**Planning Department  
Transportation Development Services**

**Re: TLC Pet and Uptown Cat Hospitals, 1300 Wyoming Boulevard, N.E.  
Traffic Circulation Layout**  
Engineer's/Architect's Stamp dated 10-24-14 (J20-D027)

**Re: TLC Pet and Uptown Cat Hospitals  
1300 Wyoming Boulevard, N.E.  
Request for Traffic Circulation Layout (TCL) for Building Permit Approval**

sheet title
Architectural Site Plan

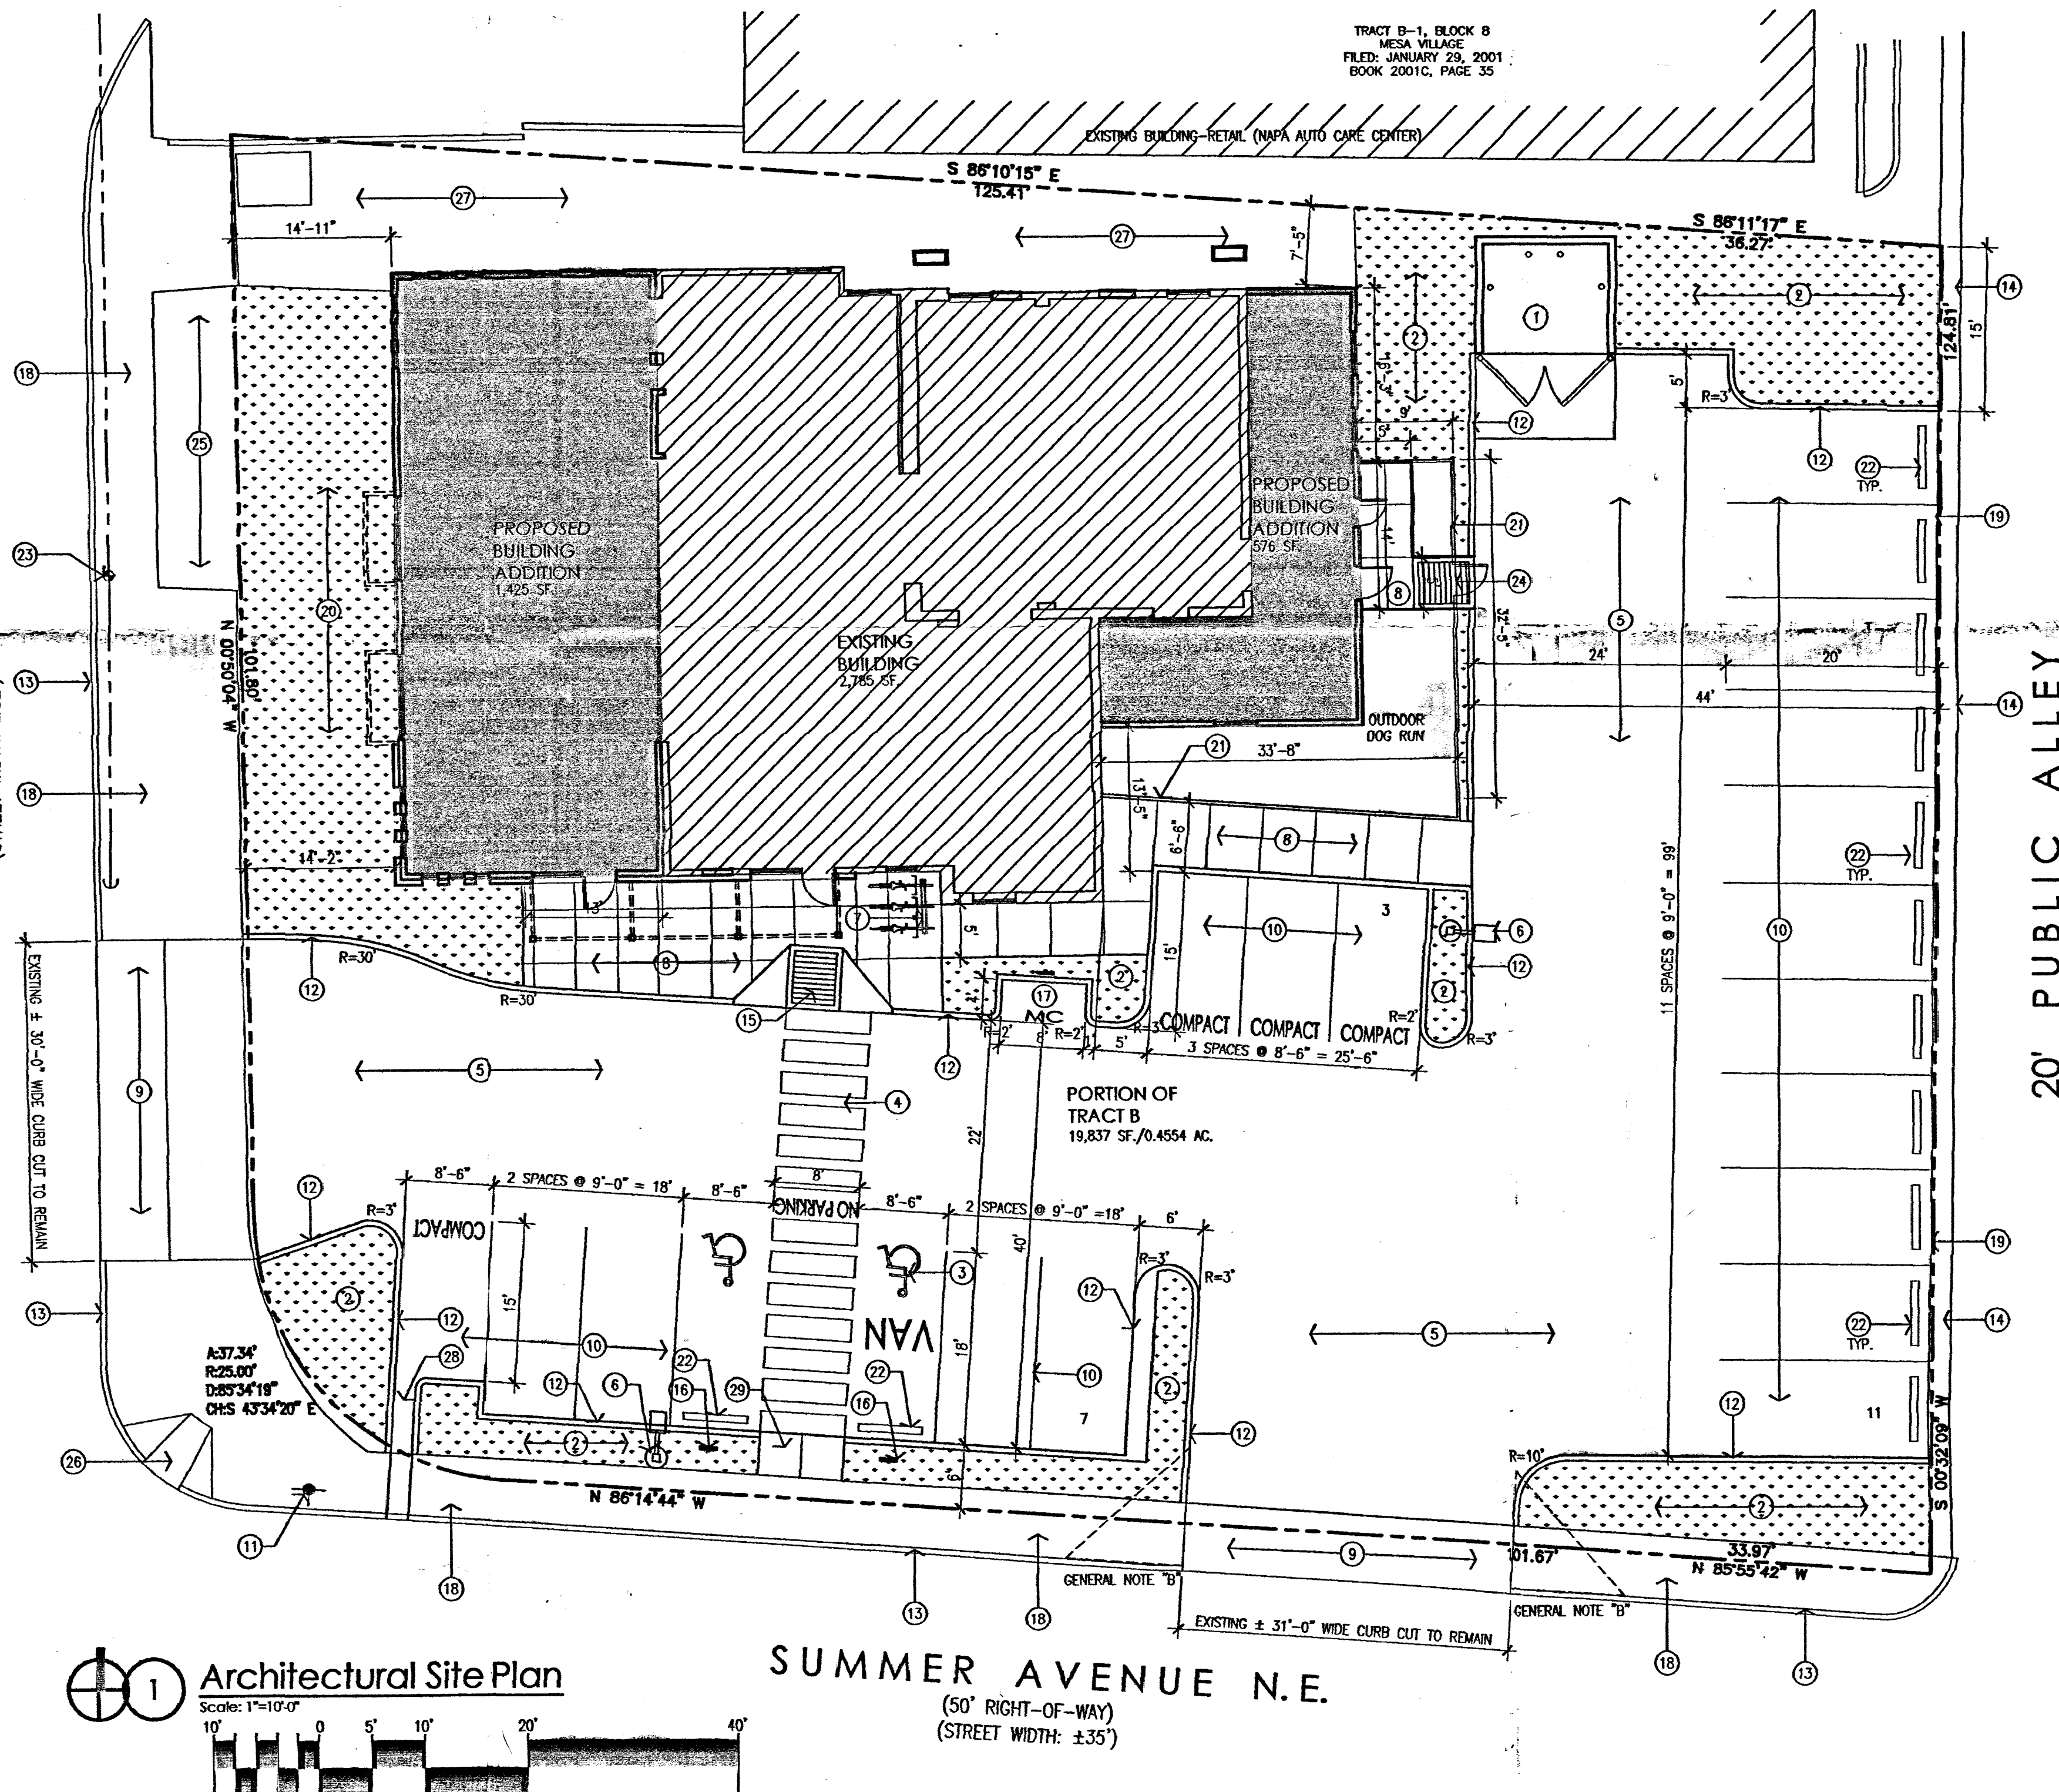
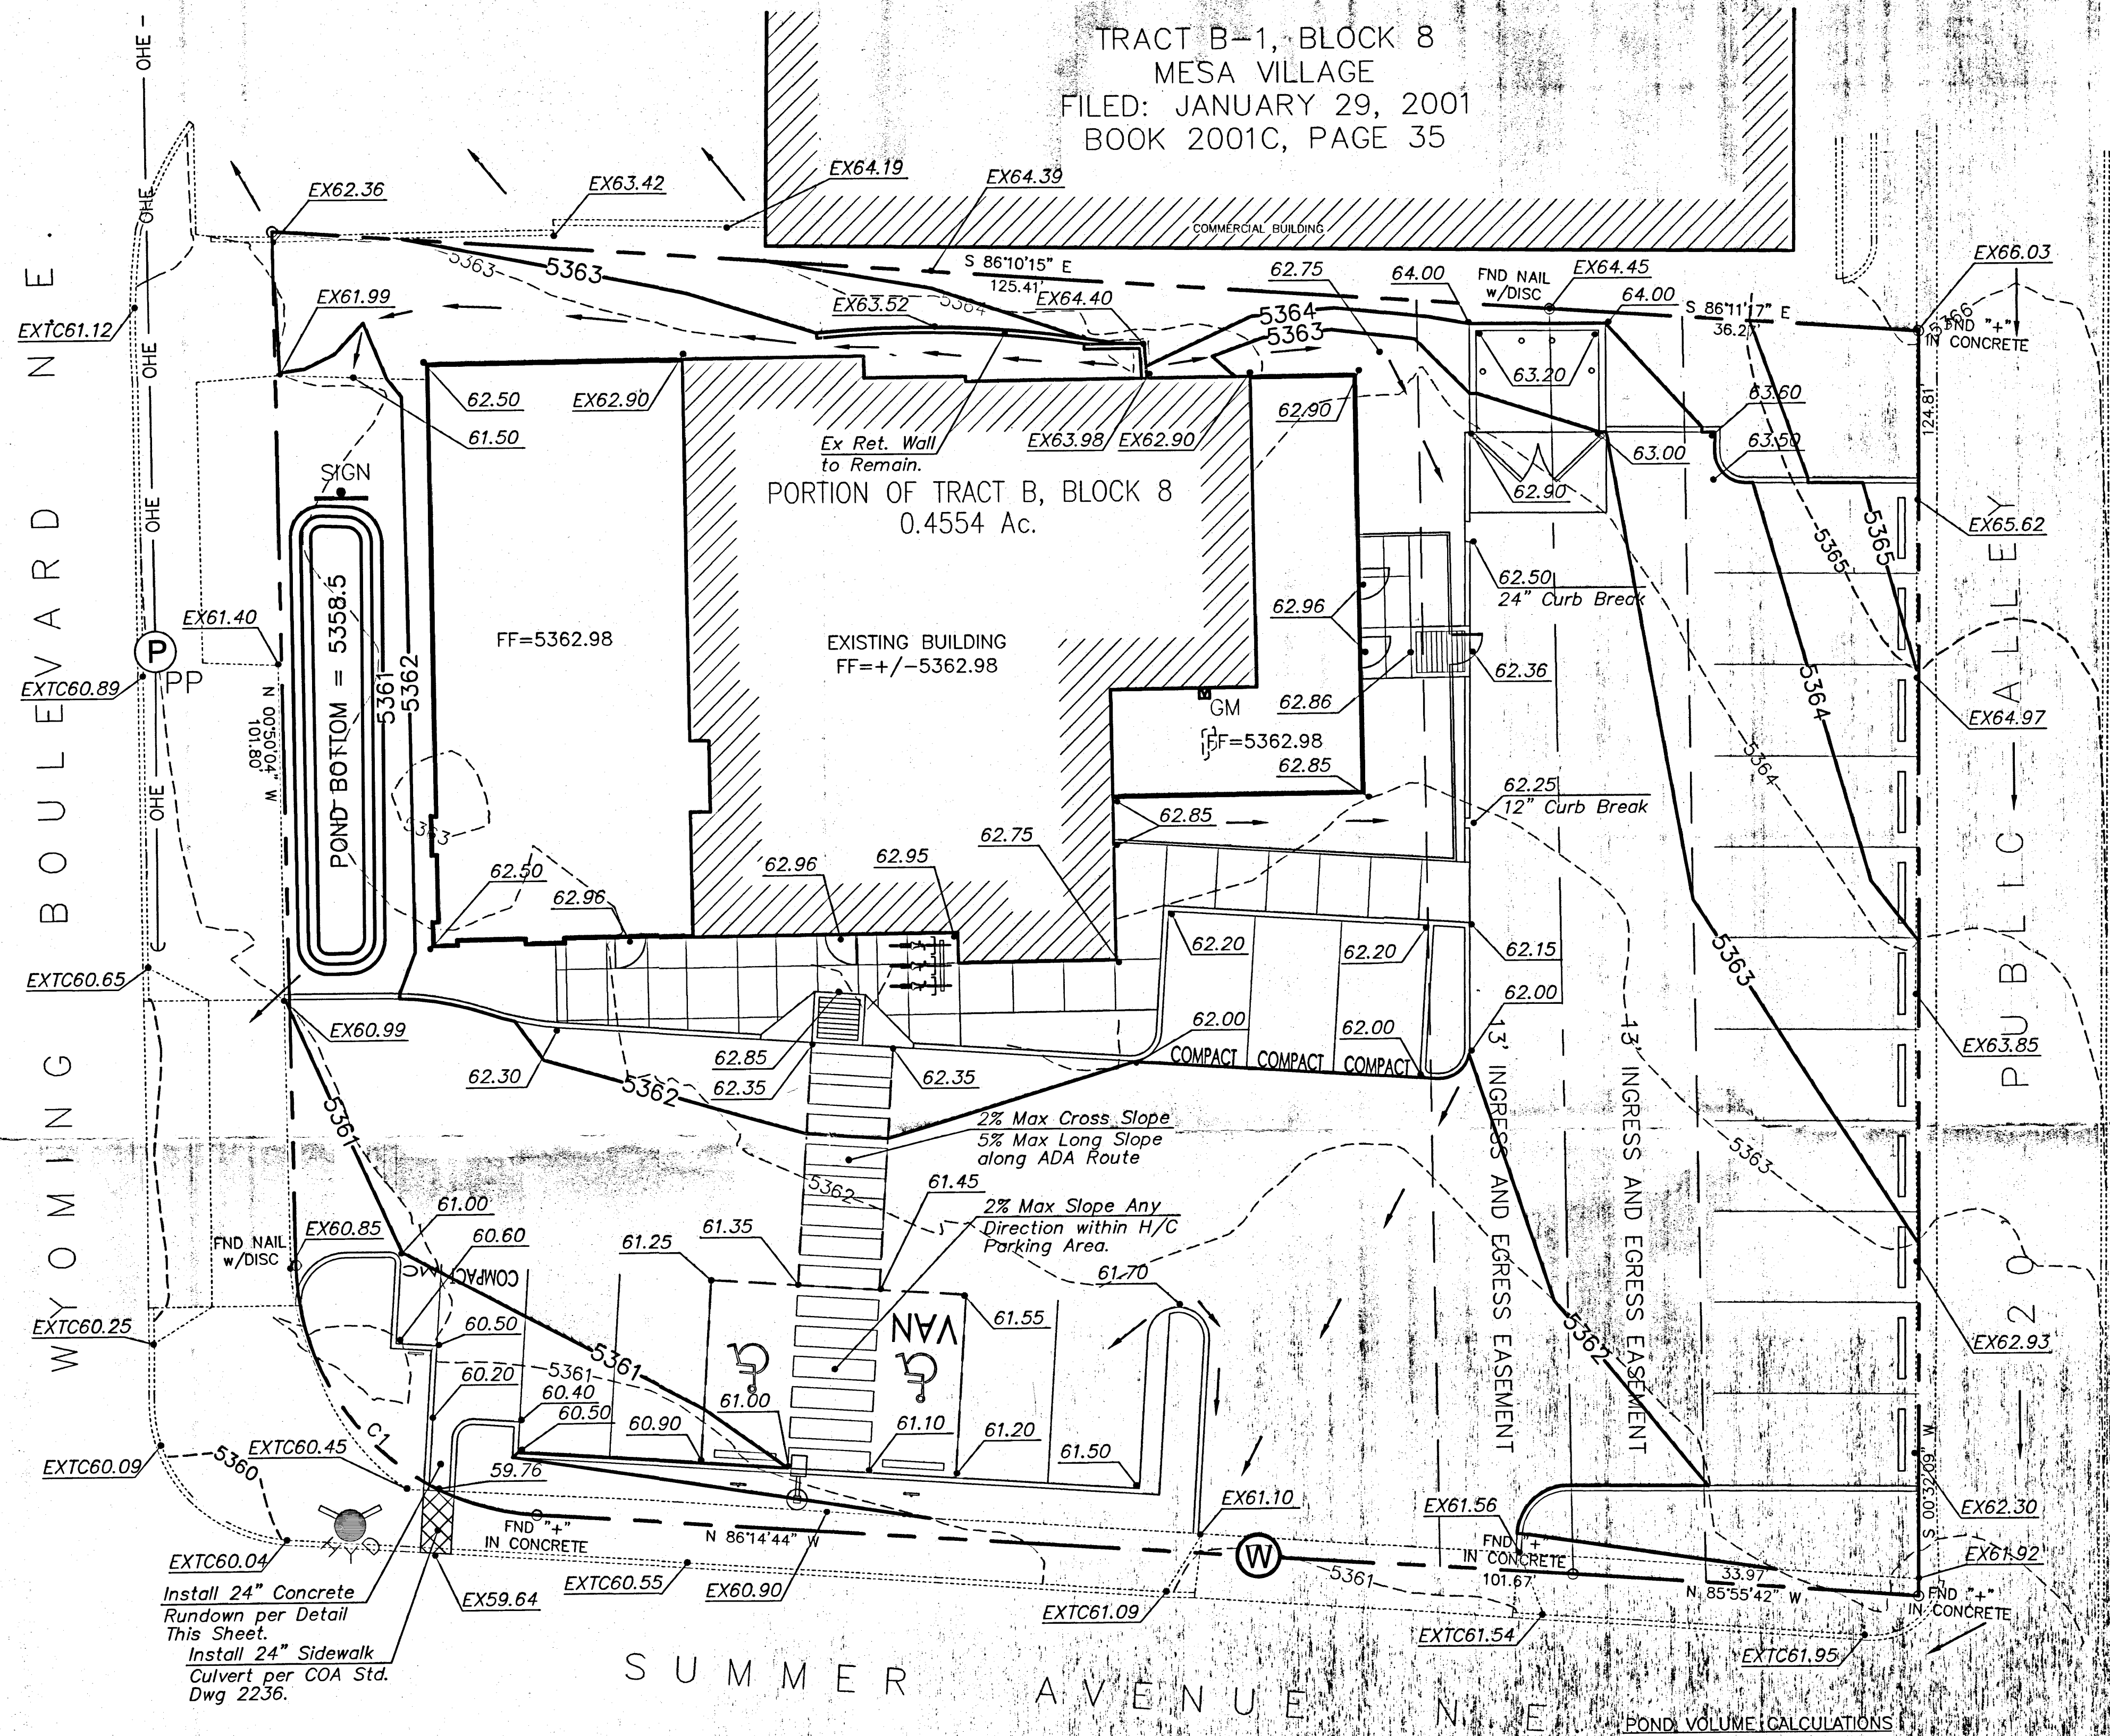
1. Please provide a vicinity map with the location of the site development in relation to surrounding streets.  
*Vicinity map, indicating the project location, is now on the site plan.*

2. Please provide a legend for the various line-types and hatching.  
*In lieu of a legend, the various line types (i.e. property lines) and hatches (i.e. new construction, existing construction and landscaping) are noted as such.*

3. Identify the existing right-of-way width, medians, and street widths for Wyoming Boulevard and Summer Avenue.  
*Right-of way and street widths are noted for Summer Ave and Wyoming Blvd.*

4. In addition to being too close to the Summer Avenue intersection, the existing drivepad on Wyoming Boulevard does not match up with the driving aisle. Revise the existing drivepad to match up with the driving aisle along the south side of the access.  
*Per our subsequent discussions, the curb returns from the drive aisle have been modified to match up with the existing drive pad.*

5. On the southwest corner of the parking lot make a correction from 3 Spaces to "2 Spaces @ 9'-0" = 18".  
*Correction made.*
6. For Keyed Note 16, the ADA van accessible sign must have the required language per 66-7-352.4C NMSA 1978 "Violators Are Subject to a Fine and/or Towing."  
*Keyed note 16 now includes this language.*

7. The ADA access aisle shall have the words "NO PARKING" in capital letters each of which shall be at least one foot high and at least two inches wide placed at the rear of the parking space so as to be close to where an adjacent vehicle's rear tire would be placed (66-1-4.1.13 NMSA 1978).  
*This has been noted on the site plan.*

8. See Figure 23.7.2 of the DPM for end of parking aisle islands Change the curb radii from 1 foot to 3 feet where shown on parking aisle islands near the end of the parking spaces. Curb radii should be 15 feet for passenger vehicle maneuvering.  
*Radii have been increased where possible.*

9. Graphically, it appears that it will be difficult to incorporate a 6-foot wide flat ADA-accessible path in front of the door in addition to a ramp with a 12:1 slope. (Make sure that both the 12:1 ramp and a 6-foot pathway can be incorporated. The ramp is only drawn at a 5-foot length).  
*The drive aisle along the south side of the building has been reduced to 22', since parking only occurs on one side of the drive aisle, to allow for a greater sidewalk against the building, which also allows for 6' from the top of the HC ramp to the building. Additionally, the ramp detail indicates a 1:12 slope.*

10. Call out curb height for Keyed Note 12. Keyed Note 12 needs to correctly point to curb for access off of Wyoming Boulevard.  
*Correction made.*
11. For ease of refuse vehicle maneuvering, move the refuse at least a few feet to the east away from the curb.  
*Approval by the refuse department is indicated on the site plan.*

12. Indicate what pavement thickness will be used for the parking lot.  
*Existing asphalt is to remain and only be resurfaced. Keyed note 5 indicates this.*

13. The proposed landscaping at the access off of Summer Avenue may interfere with the sight distance. Provide clear site triangle. (See DPM Manual Page 23-74 of the DPM for Mini Clear Site Triangles for Driveways.)  
*Clear site triangles are indicated at the drive pad off of Summer Ave.*

14. Please add the following note to the clear sight triangle: "Landscaping and signage will not interfere with clear sight requirements. Therefore, signs, walls, trees, and shrubbery between 3 and 8 feet tall (as measured from the gutter pan) will not be acceptable in this area."  
*Note included as General Note B.*

15. Please specify the City Standard Drawing Number when applicable.  
*City Standards are noted where applicable.*
16. Work within the public right of way requires a work order with DRC approved plans.  
*If right-of-way work is required, DRC plans will be produced. General Note D indicated that no public work is anticipated.*
